Our Ref: NW/ARU/19/25A

Date 3rd December 2019

RE: Land east of Shripney Road and south of Haddan House, Shripney Road Bersted PO22 9NW

Thank you for your correspondence of 31st September 2019, advising me of an 'Outline application with some matters reserved for up to 46 No dwellings together with access. This application is a Departure from the Development Plan & may affect the character & appearance of the Shripney Conservation Area.' at the above location, for which you seek advice from a crime prevention viewpoint.

DRAWING TITLE:
Preliminary Illustrative Layout

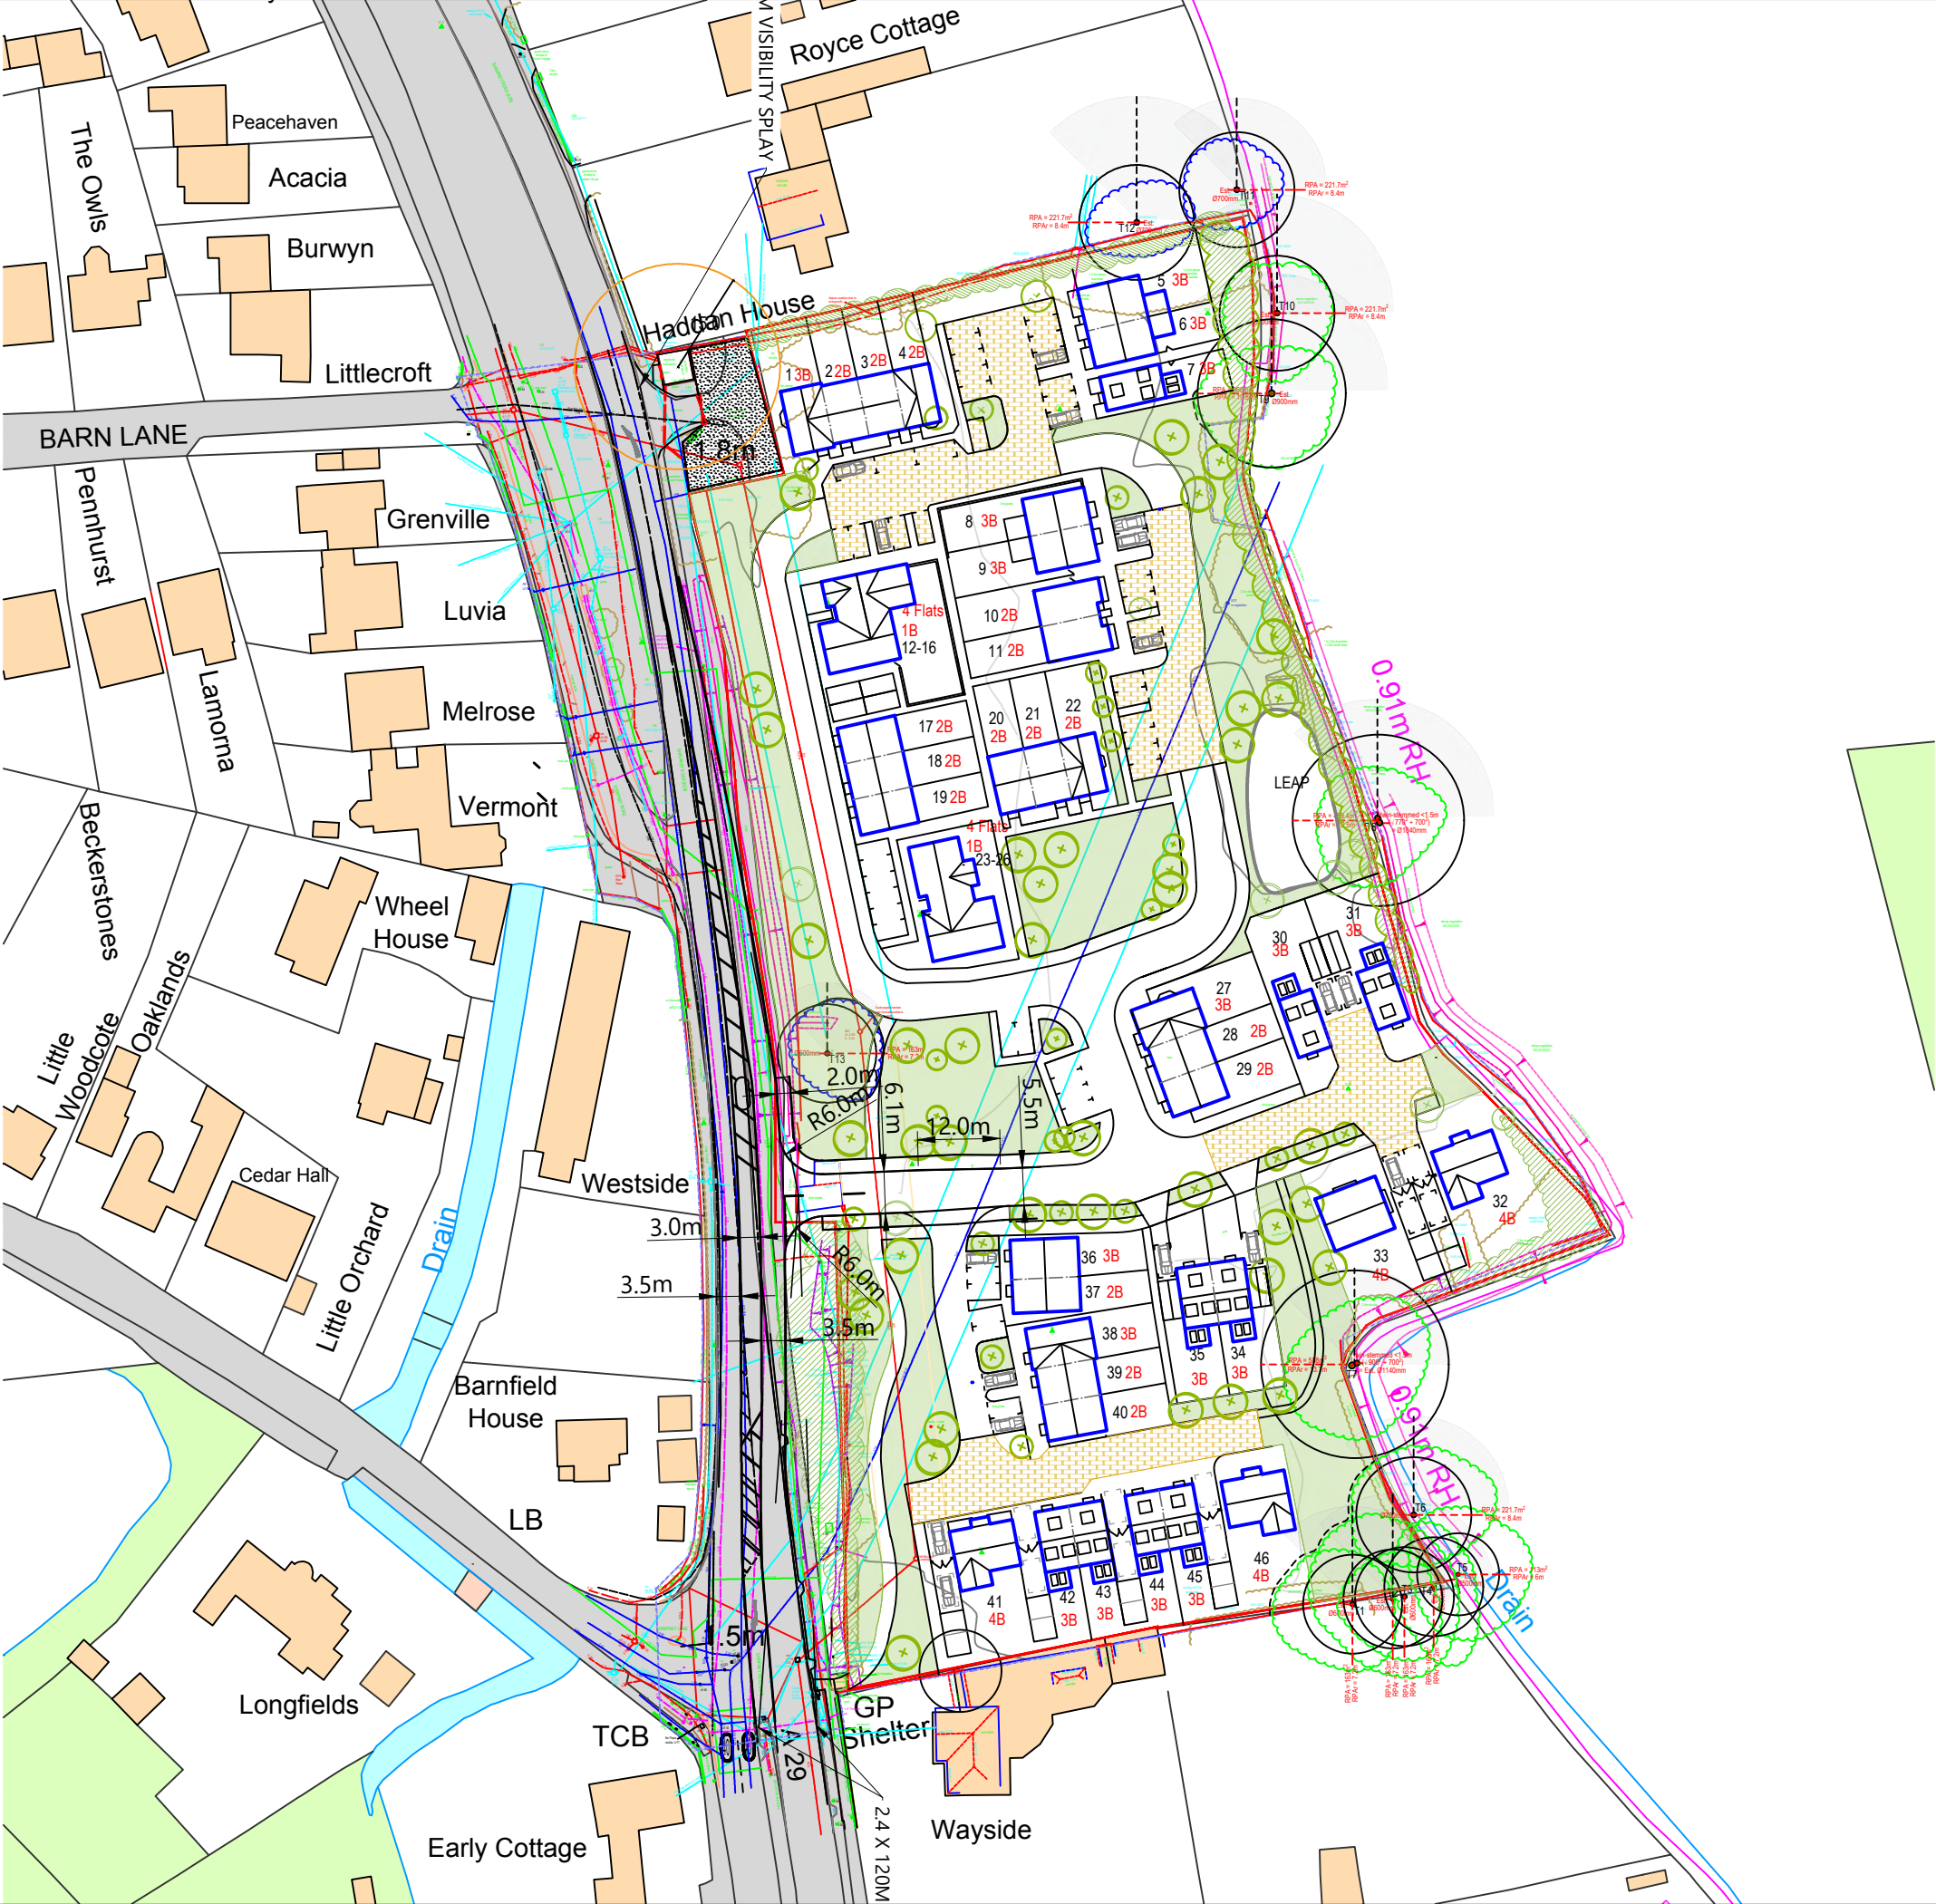
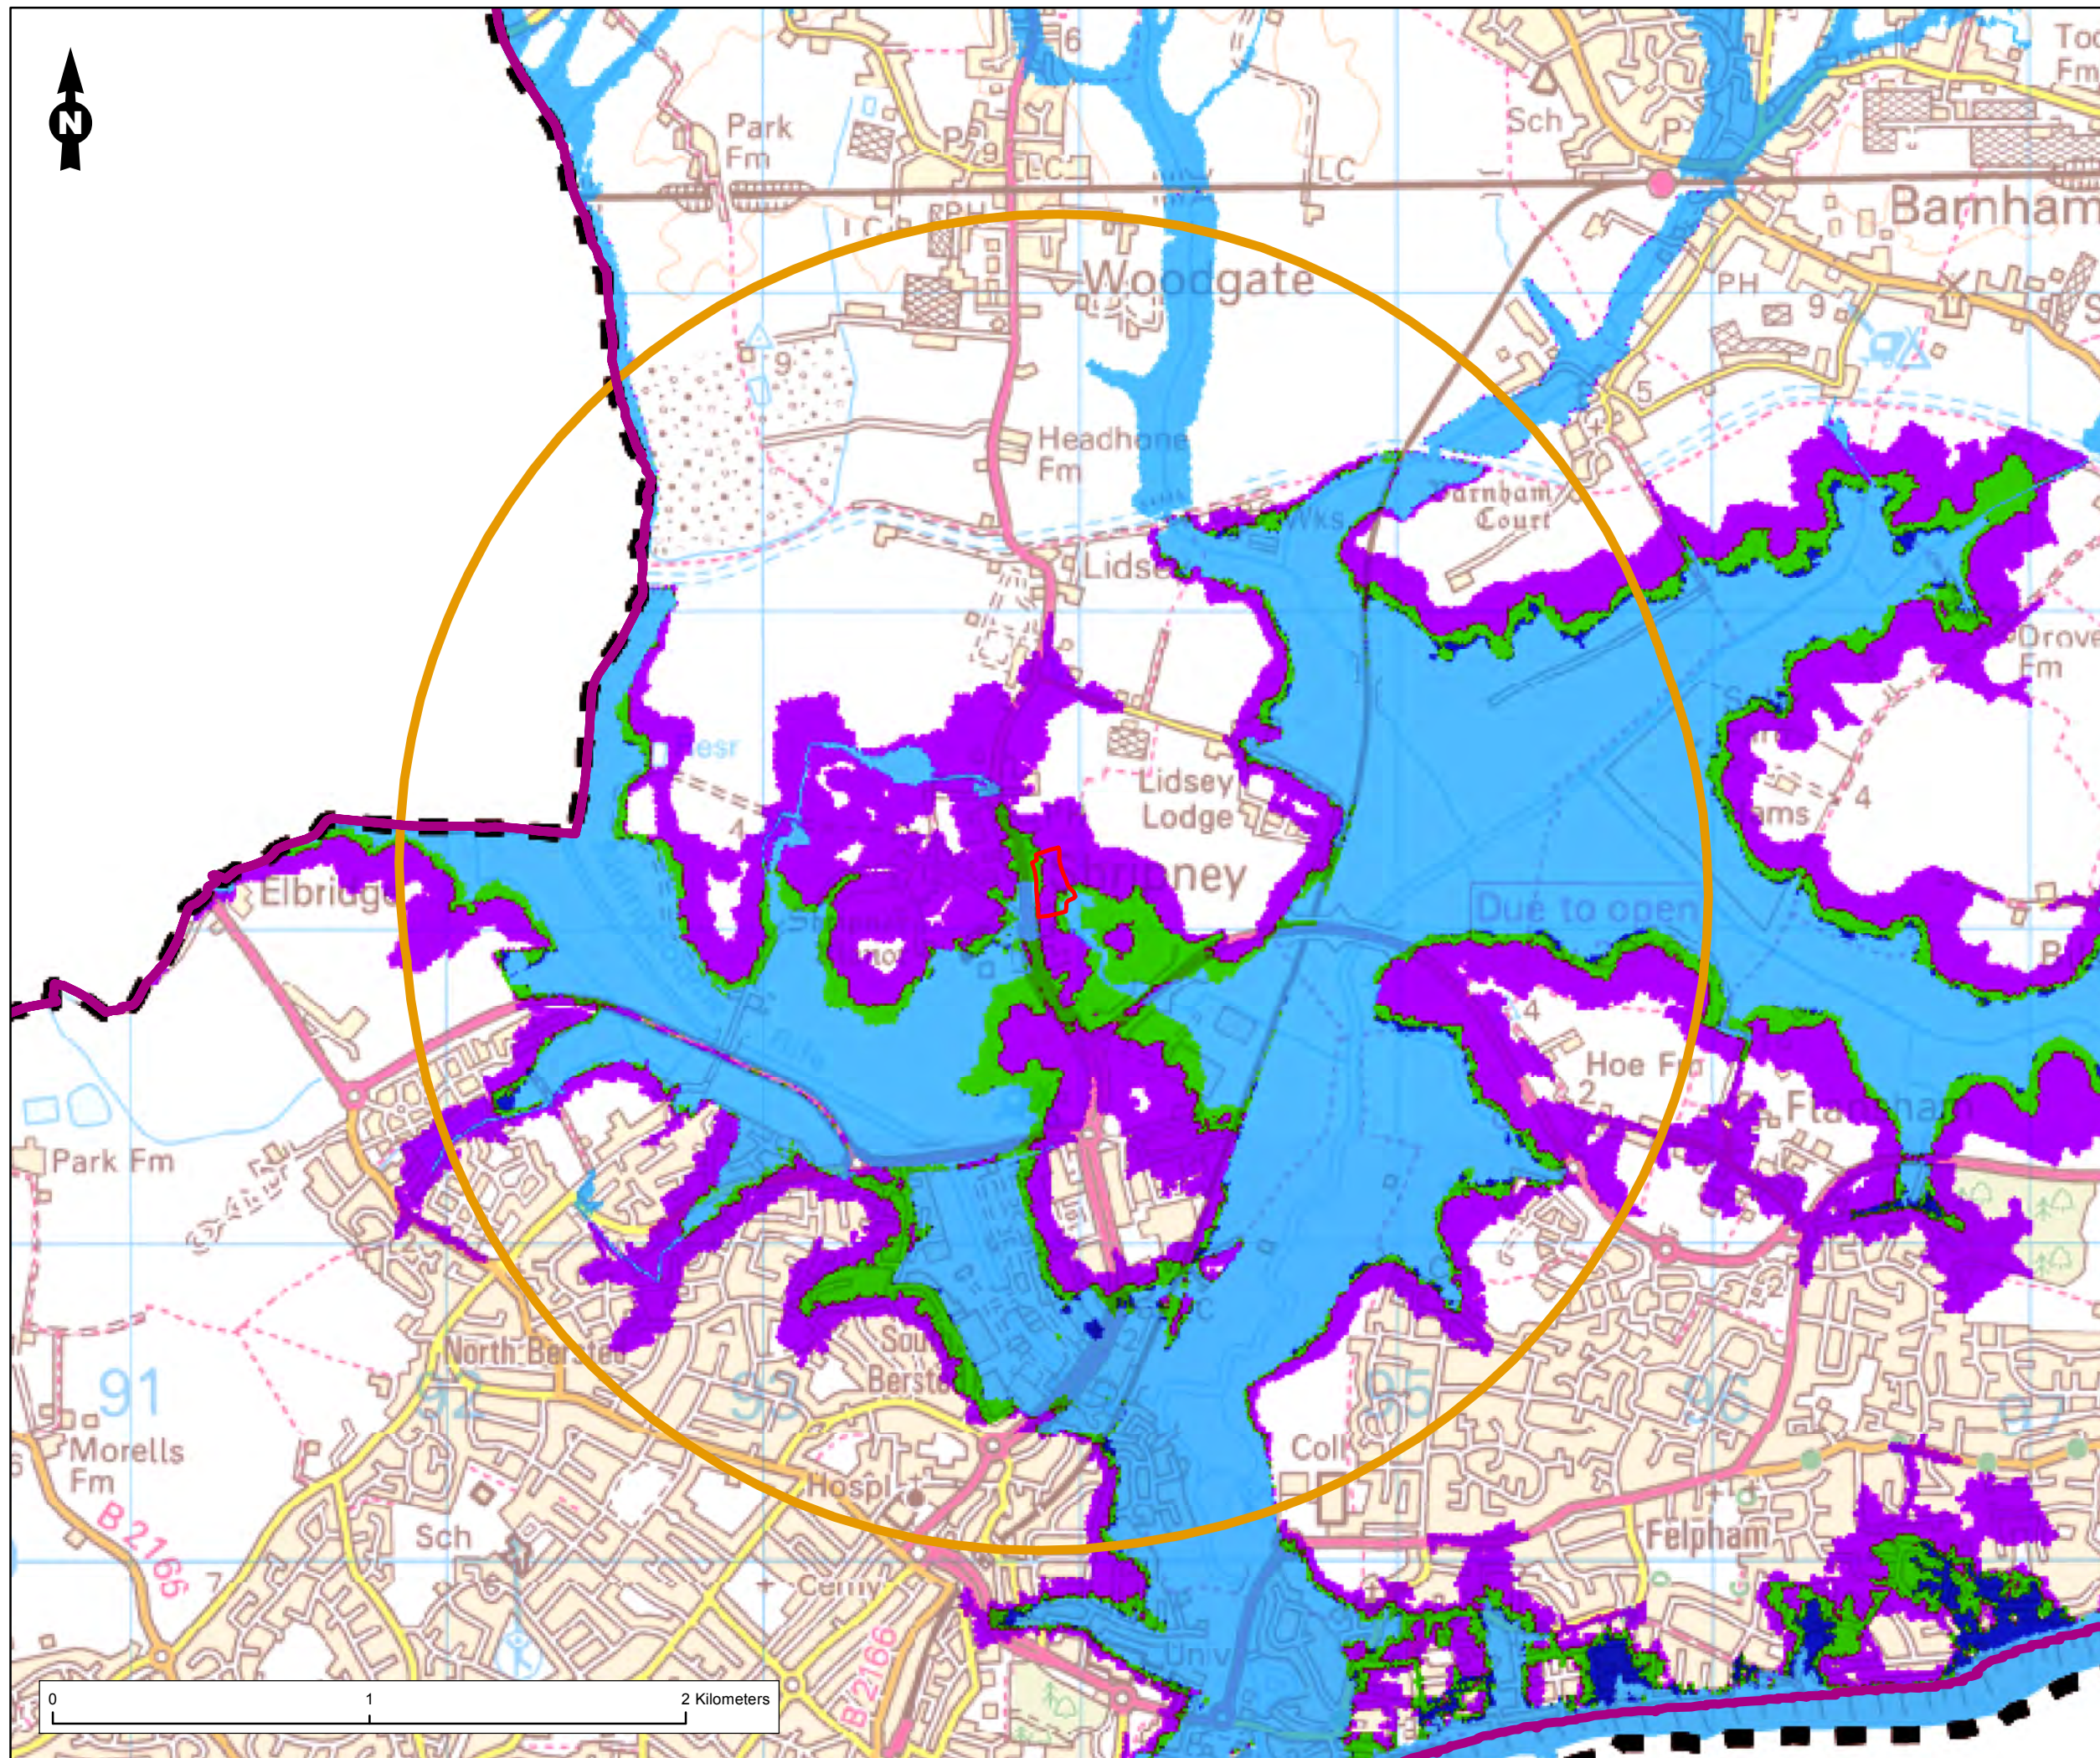
I have a slight reservation regarding the access footpath between the houses centrally located in the north part of the site as the access path provides easy access through the middle of the rear and sides of some back gardens.

The footpath that is located close to the entrance to the development and travels north to south parallel with the A29 road must be a sufficient distance within the junction to allow southbound vehicles on the A29 to see pedestrians clearly as they turn eastwards from the road into the application. Likewise pedestrians crossing the entrance road and using the footpath must be able to clearly see vehicles turning from the A29 southbound lane in particular, to avoid any potential collisions.

I note the A29 proposed pedestrian crossing is just north of the entrance of the application. There may be a desire route from the houses on the north side of the access road towards the pedestrian crossing cutting across the grassed area of the north east corner of the access road. (I am aware a pedestrian crossing has also been suggested as an alternative, south of the junction).

Other than the main access road and the north and south ends of the perimeter footpath that runs parallel with the A29, the development backs onto agricultural fields with no adjoining public rights of way. As far as possible the perimeter of the application must have a secure perimeter. Any perimeter hedging should be dense to prevent unauthorised access to the development. Gaps in the hedgerows around the perimeter should be sealed with planting or fencing to prevent unauthorised access through them

In circumstances that require a more open feature such as a garden overlooking a rear parking court or a rear garden pathway, 1.5metre high close board fencing topped with 300mm of trellis can achieve both security and surveillance requirements. This solution provides surveillance into an otherwise unobserved area and a security height of 1.8 metres. Gates that provide access to the side of the dwelling or rear access to the gardens must be robustly constructed of timber, be the same height as the adjoining fence and be lockable from both sides. Such gates must be located on or as near to the front of the building line as possible.

In the immediate vicinity of the junction with the A29 Bognor Road I recommend as a general recommendation where good visibility is needed shrubs should be selected to have a mature growth height no higher than 1 metre, and trees should have no foliage or lower branches below 2 metres which allows 1 metre field of view between them. A large tree canopy can block natural light and also restrict the effectiveness of street lighting. Branches may also come into collision with the street lights.
